From: Adrian Dowd
Sent: 10 August 2011 16:28
To: Jane Tucker
Subject: FW: Consultation on planning application 3/2011/0425 & 3/2011/0426 29 Church Street, Ribchester

From: Hornby, Mark [mailto:Mark.Hornby@lancashire.gov.uk]
Sent: 28 July 2011 11:47
To: Adrian Dowd
Subject: FW: Consultation on planning application 3/2011/0425 & 3/2011/0426 29 Church Street, Ribchester

Proposed Garages and
Site Layout

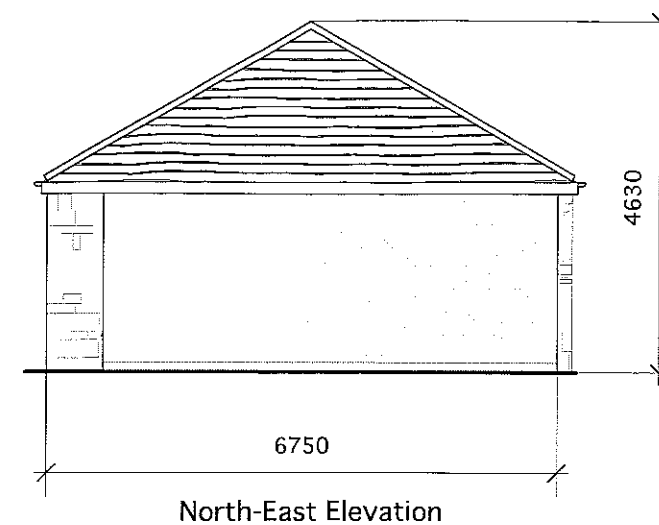
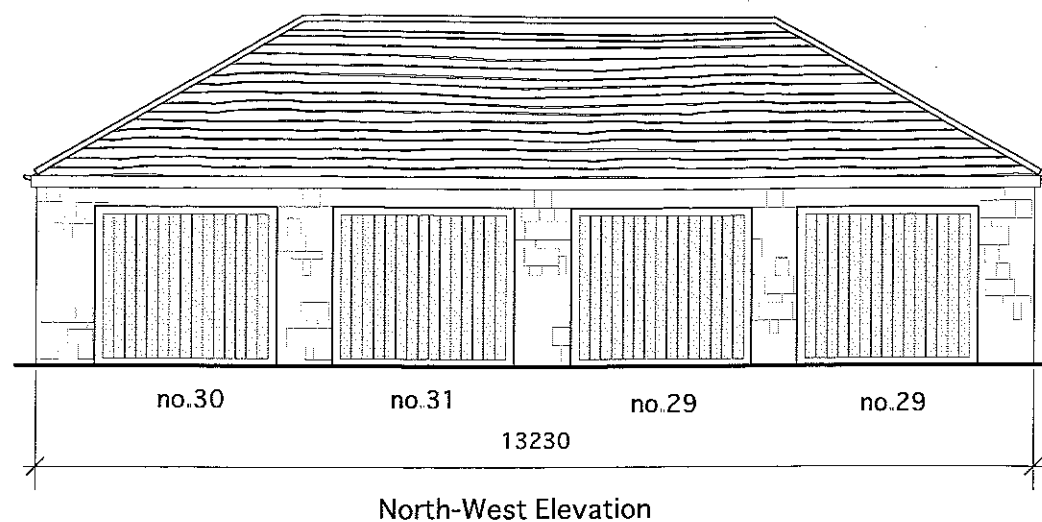
Whilst the access point for this proposal has very restricted visibility, it is an existing access with dropped kerbs on to a slow speed road and would help to alleviate the existing congested parking situation in the locality. Provided that the turning areas shown on the plans are provided to obviate vehicles reversing out on to Church Street, I have no objection to this proposal.
